Application No: FG/46/20/PL  
Site Address: The Tudor Close Public House Ferringham Lane Ferring BN12 5NQ  
Description of works: Conversion of the existing Public House (Class A4) to create 7 No residential units comprising 5 No 1-bedroom units & 2 No 2-bedroom units & the erection of 2 No 2-bedroom semi-detached chalet bungalows with associated car parking & landscaping. This application may affect a Public Right of Way.

Thank you for your internet representation made on 19th May 2020 which has been recorded as an objection with the comments as follows:

Ferring Parish Council object to elements of this proposal. The Tudor Close public house/restaurant has been a significant part of the community in Ferring for many years and a major feature of the street scene. While we understand the financial and commercial realities, we seek to ensure that any redevelopment is reasonable in its impact on the locality.

Drawing Title:
Landscape Plan
Block Plan
As Proposed

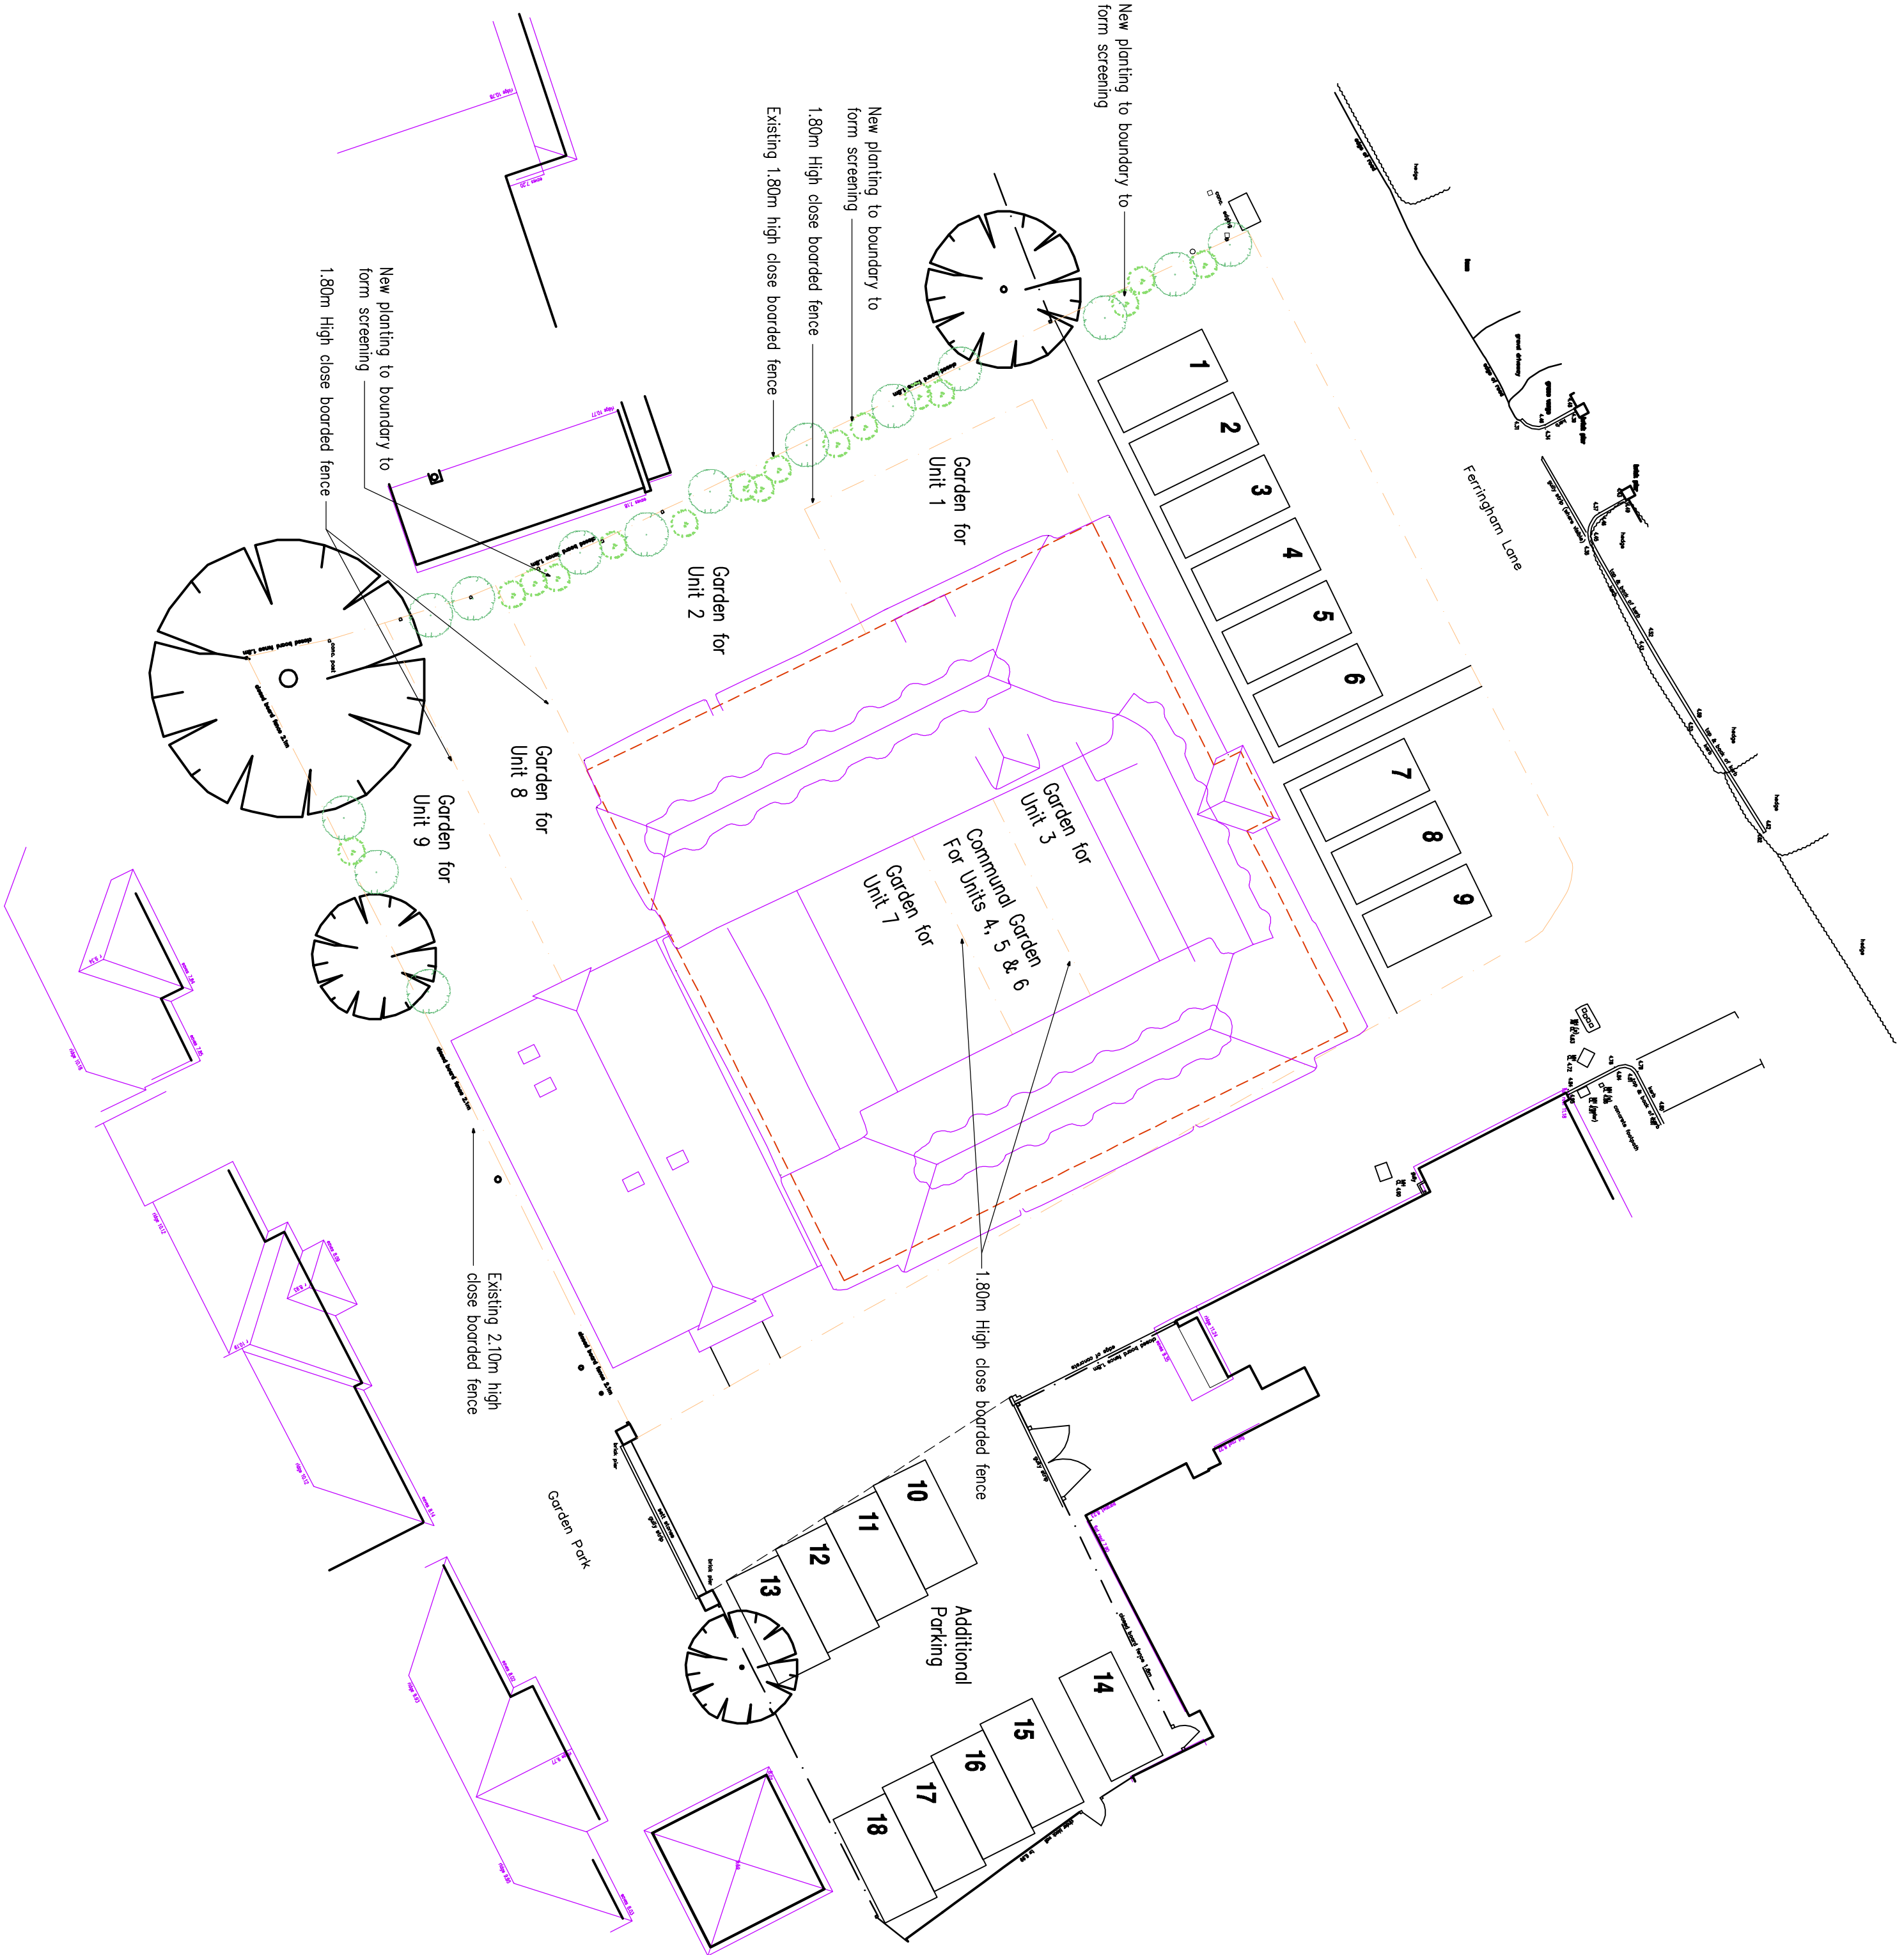
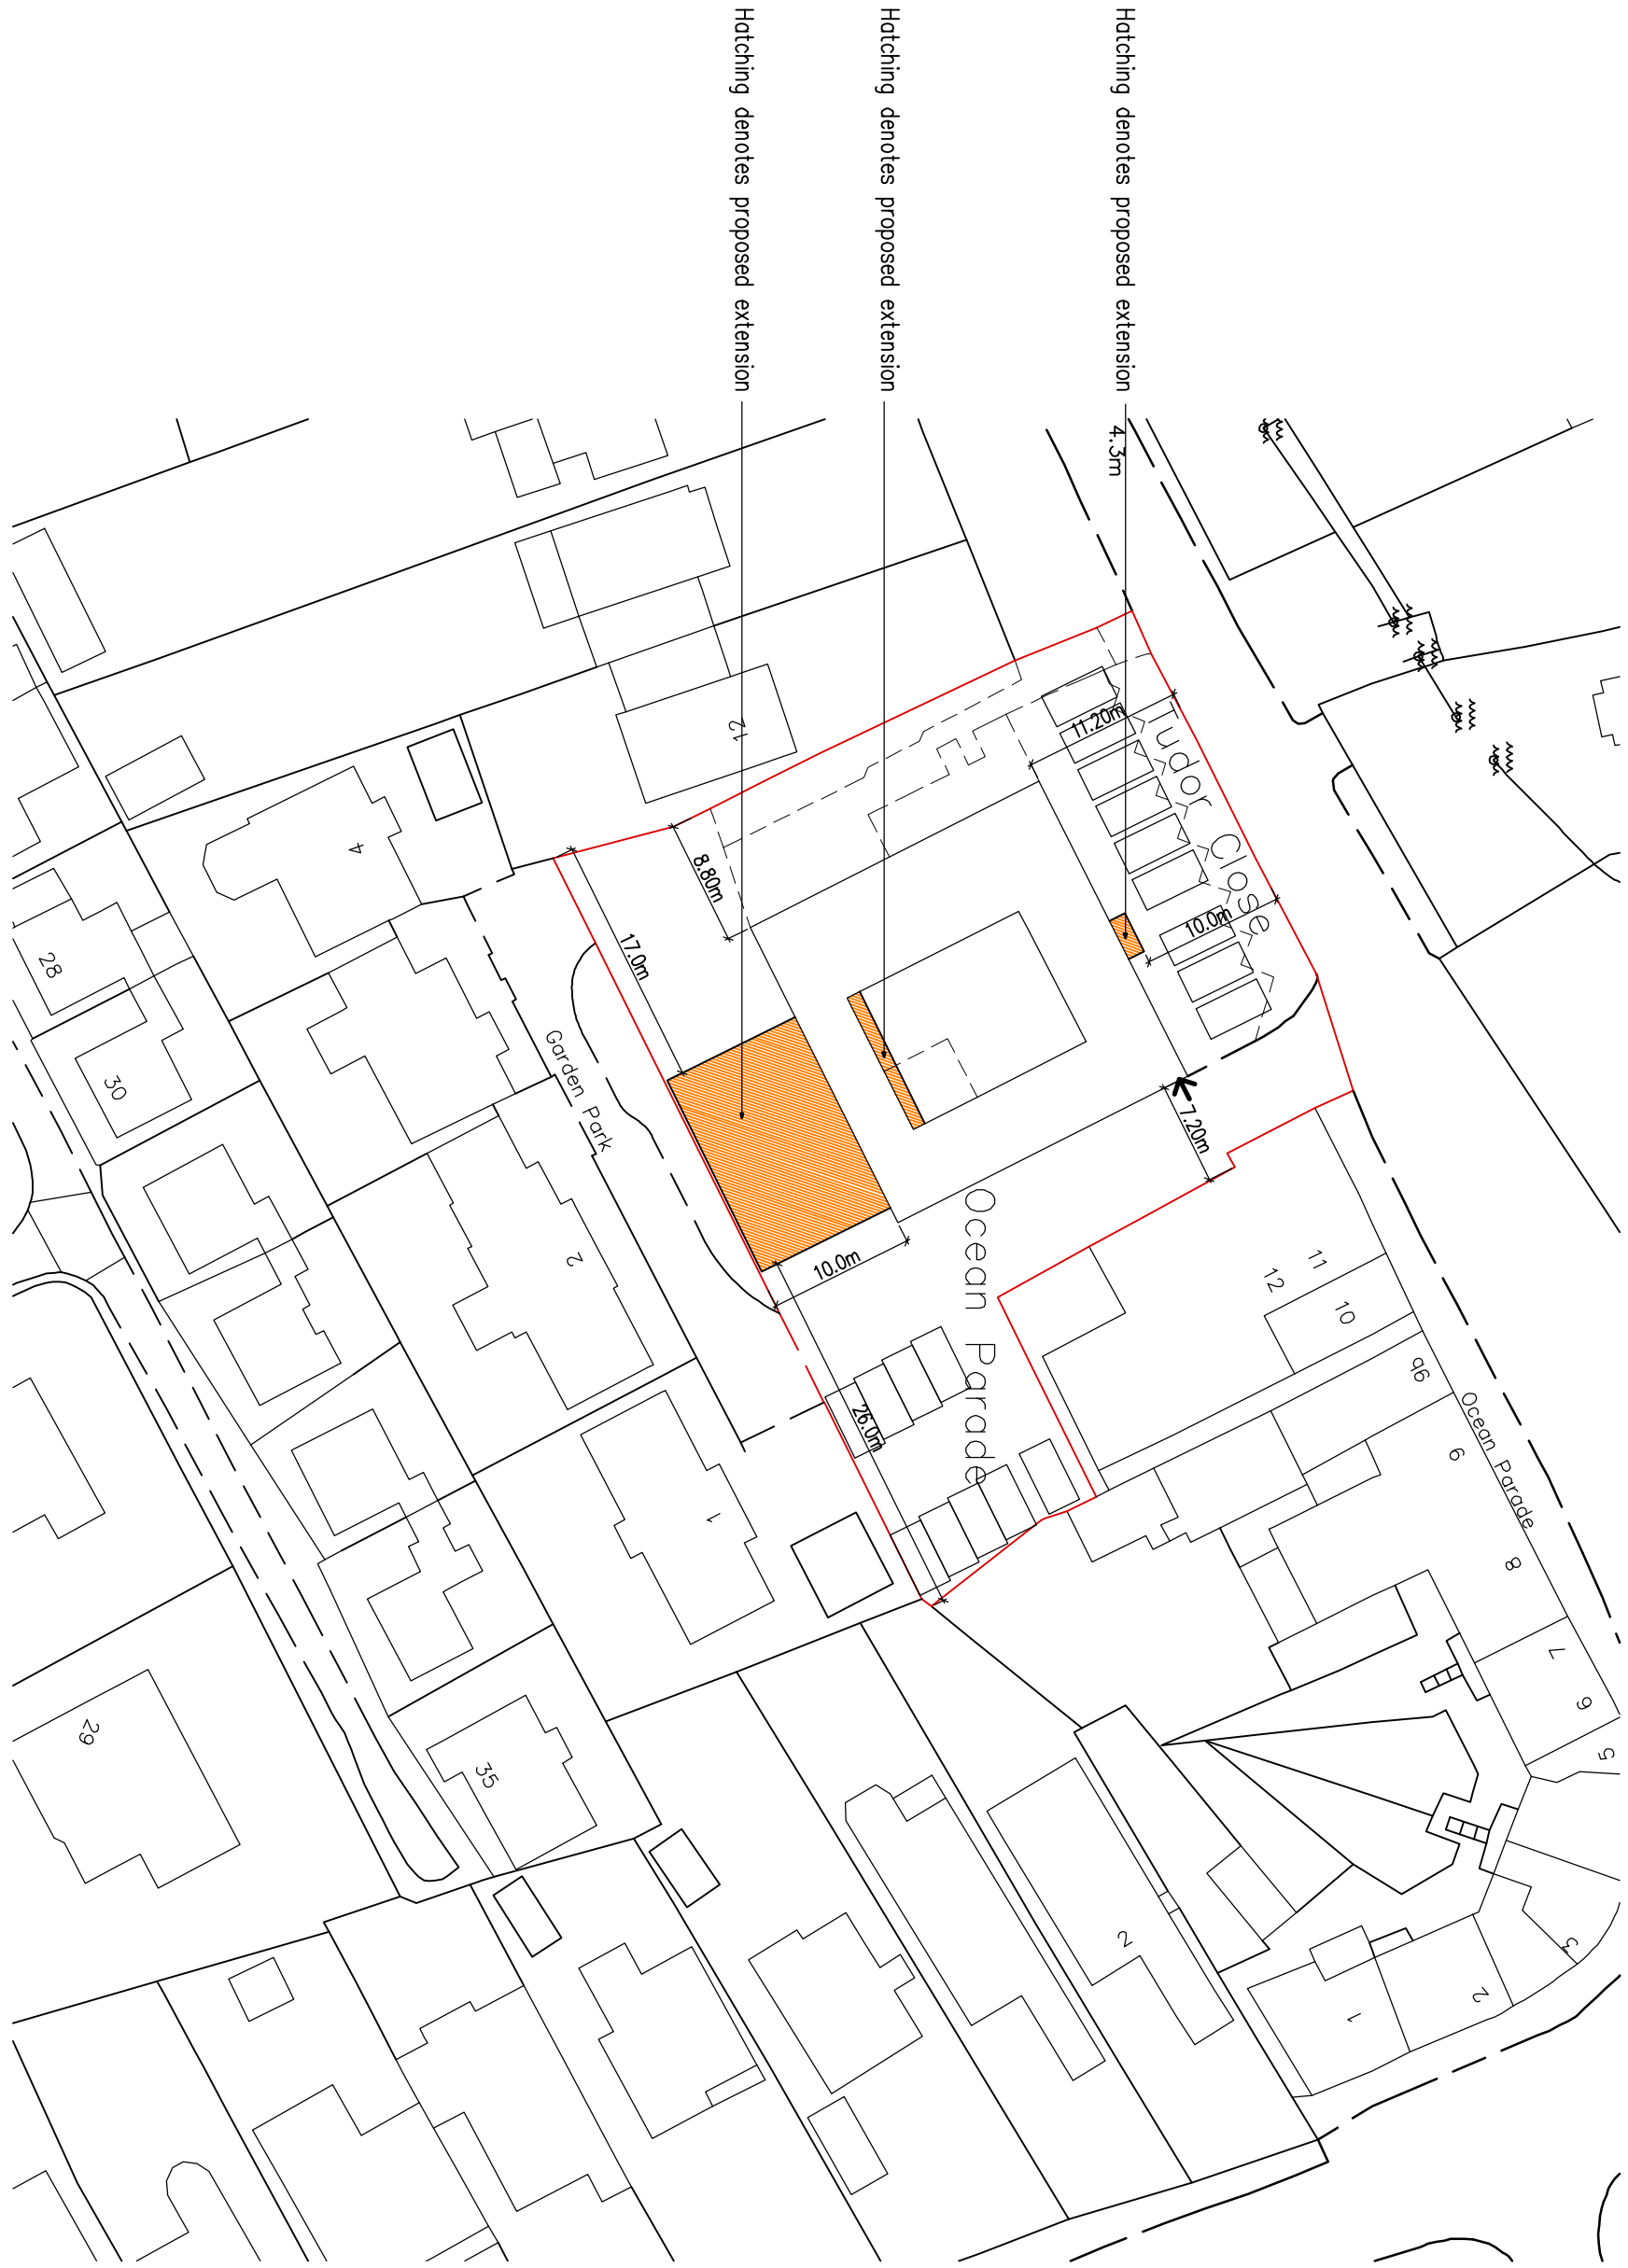
We welcome the retention of the main structure but have concerns regarding the additional new chalet properties proposed at the rear of the site. It is our contention that the size and scale of these dwellings constitutes overdevelopment of the site, detriment to the visual impact of the street scene and dominance over the bungalows on the south side of the site.

With the parking bays not being directly adjacent to the individual dwellings, it is not clear how electric vehicle charging points will be incorporated into the scheme. It will be essential that the character of the building is preserved and protected against any visual impact of external hardware and infrastructure (for example,
